CITY OF ALBUQUERQUE

December 20, 2024

Re: Burger King
4760 McMahon Blvd. NW
30-Day Temporary Certificate of Occupancy
Transportation Development Final Inspection
Architect's Stamp dated 08-20-22 (A12-D001B)
Certification dated 12-11-24

A TRAFFIC CIRCULATION LAYOUT
 SCALE 1/2" = 1'-0"

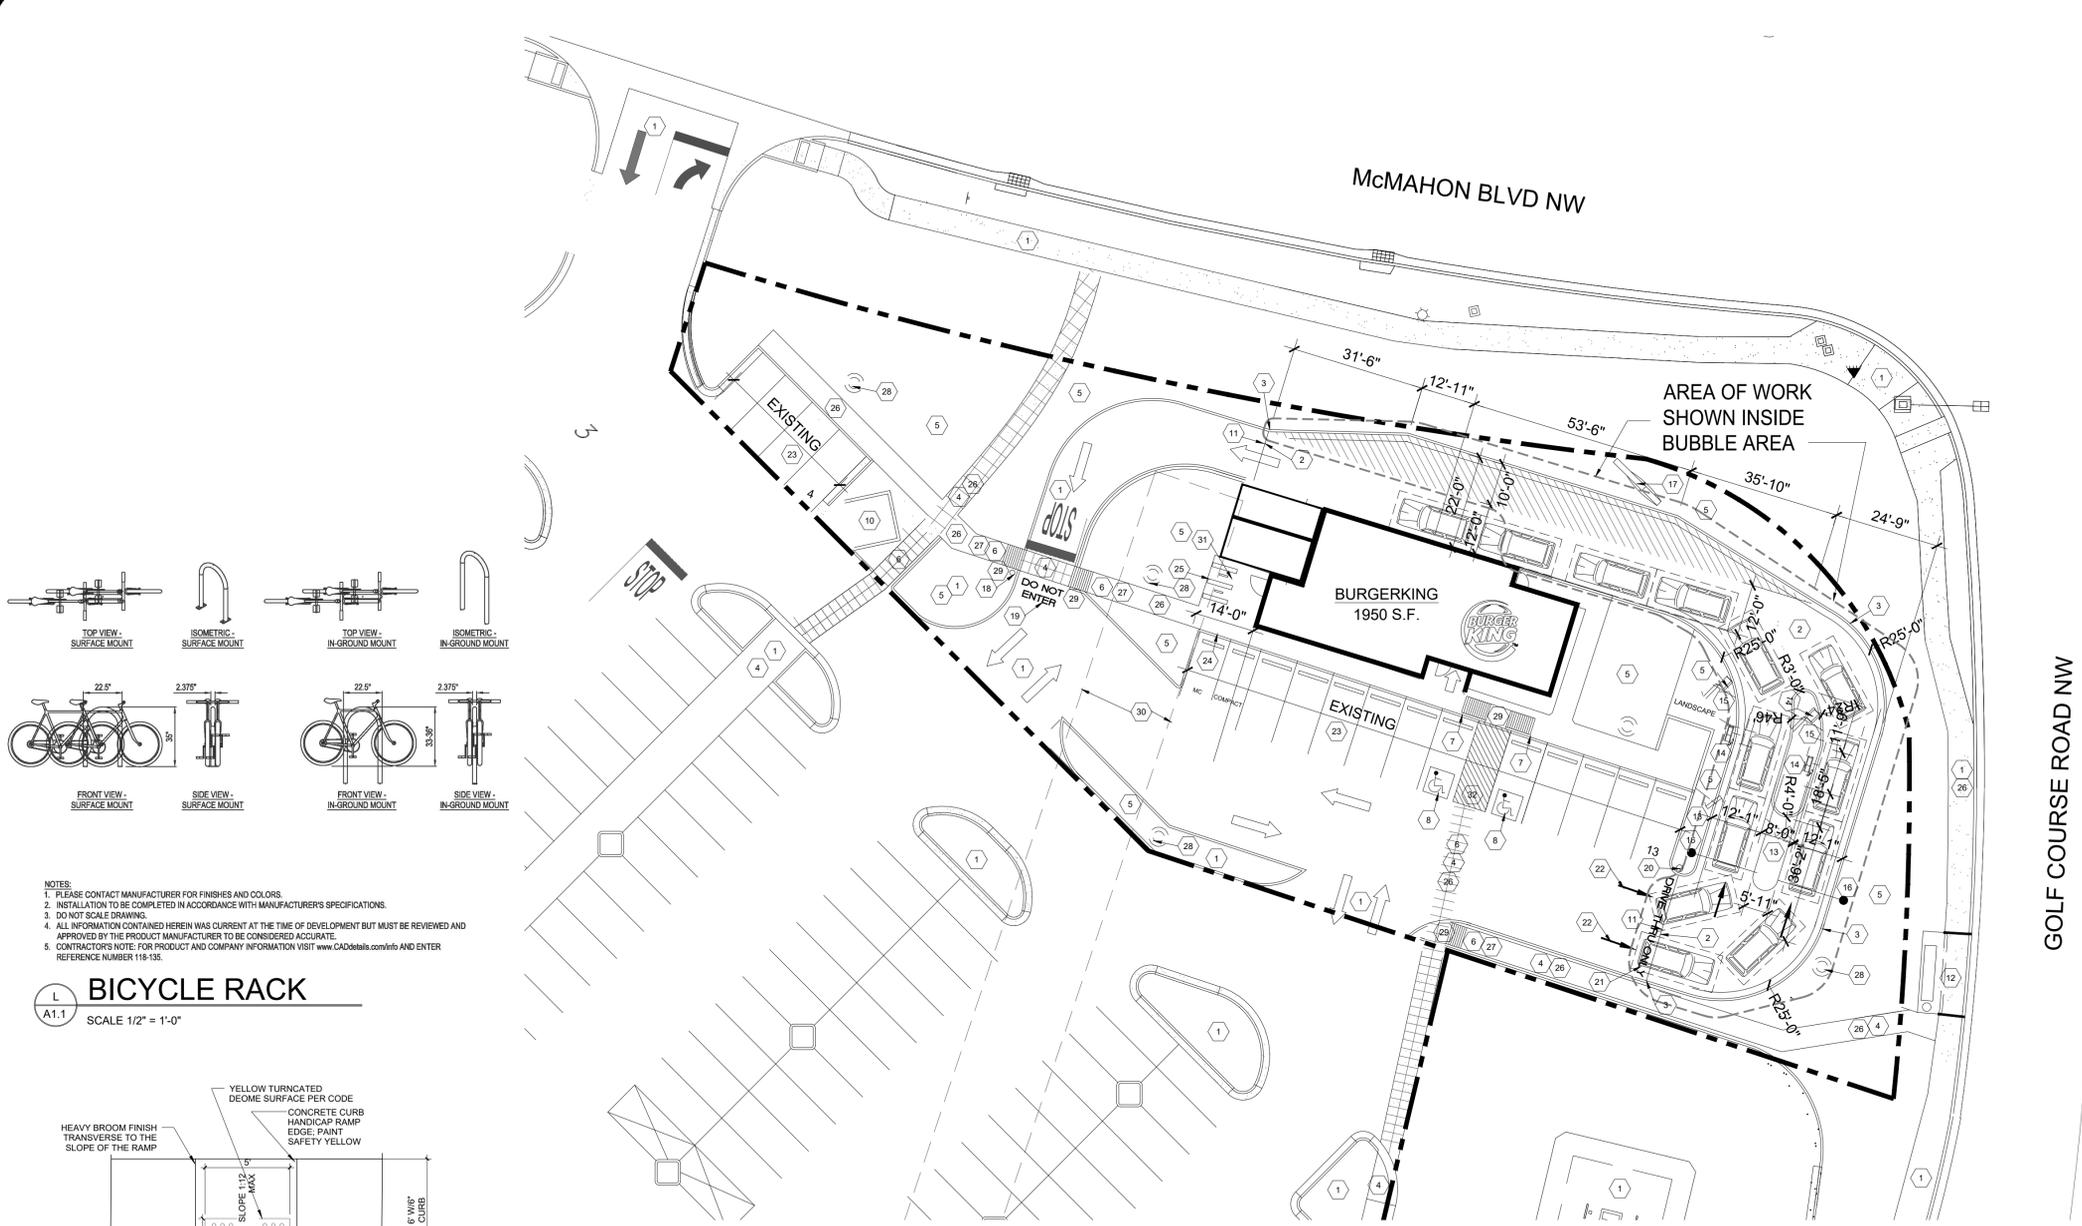
- The ADA access aisles shall have the words **"NO PARKING"** in capital letters, each of which shall be at least one foot high and at least two inches wide, placed at the rear of the parking space so as to be close to where an adjacent vehicle's rear tire would be placed. (66-1-4.1.B NMSA 1978). An ADA aisle spot must be painted with blue stripes.
